Ref: SSD Modifications (SSD-73228210-Mod-1)

Proposal: MOD 1 - Tree removal, HPC payment staging and Construction Staging

Property: 129-153 Parramatta Road and 53-75 Queens Road, Five Dock

Figure 1: showing proposed design footprint & site tree removal plan

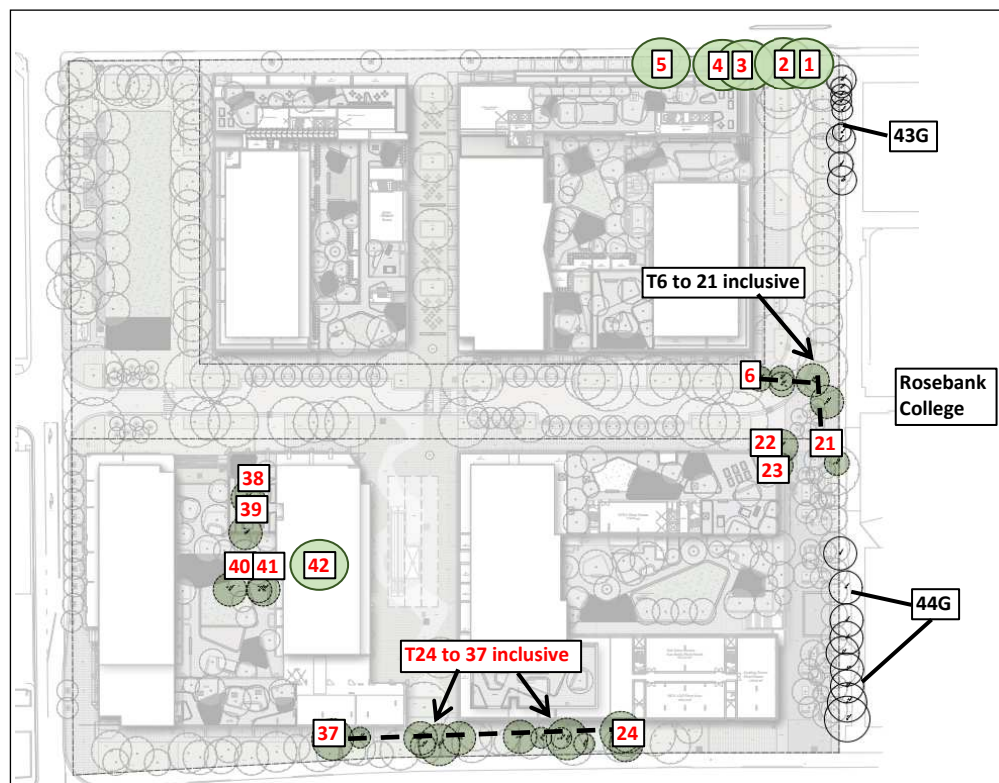
The Arboricultural Impact Assessment and associated documentation do not sufficiently demonstrate that tree removal is the only viable option. In several instances, the reasons for removal relate to demolition of adjacent buildings or walls, not new construction. Council's Tree Services Coordinator considers that alternative design and construction methods could facilitate tree retention without significantly altering the proposed development footprint.

For the above reasons, Council objects to the proposed tree removals as part of the current modification application on both arboricultural and heritage grounds. It is recommended that the Department require the applicant to:

Figure 3, showing part Rosebank College tree Group 44_{x12}

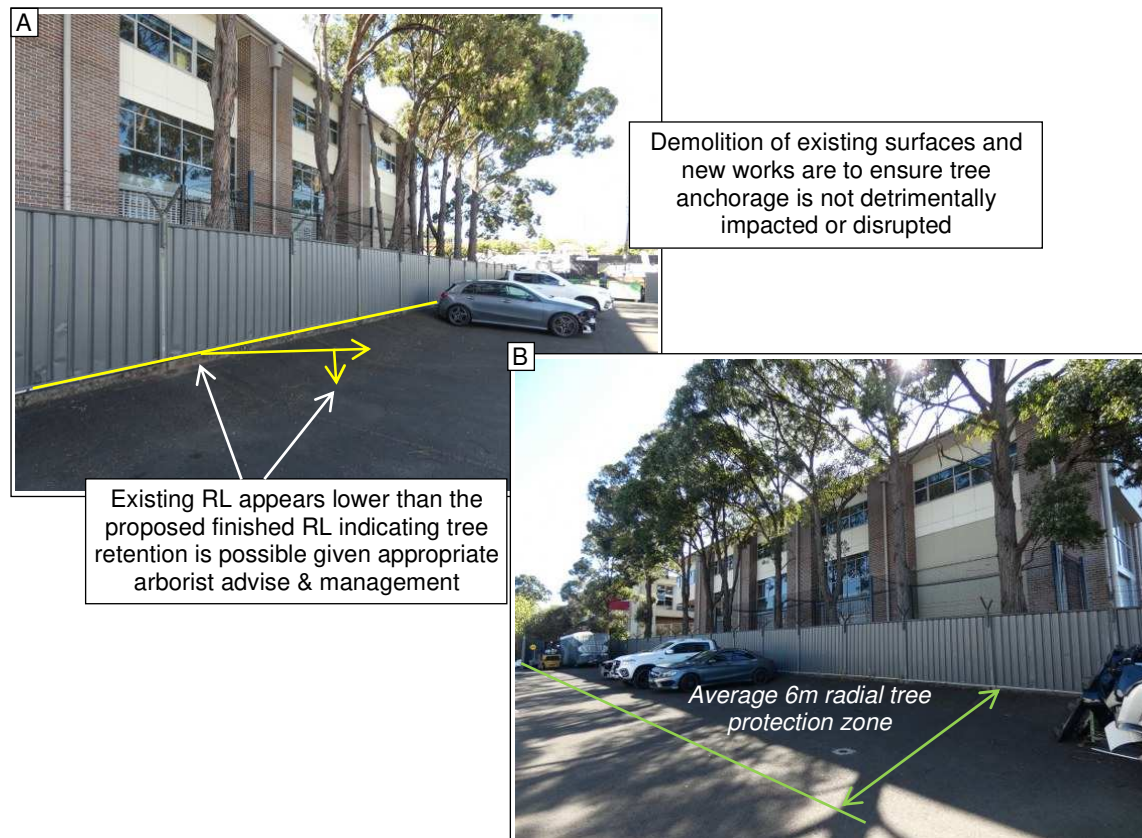
Critical details such as root mapping and assessment of structural dependency of trees on adjacent retaining walls are missing. For example, no evidence has been provided to confirm that Tree T44.9 relies structurally on the retaining wall proposed for demolition, nor has retention of part of the wall been properly explored.
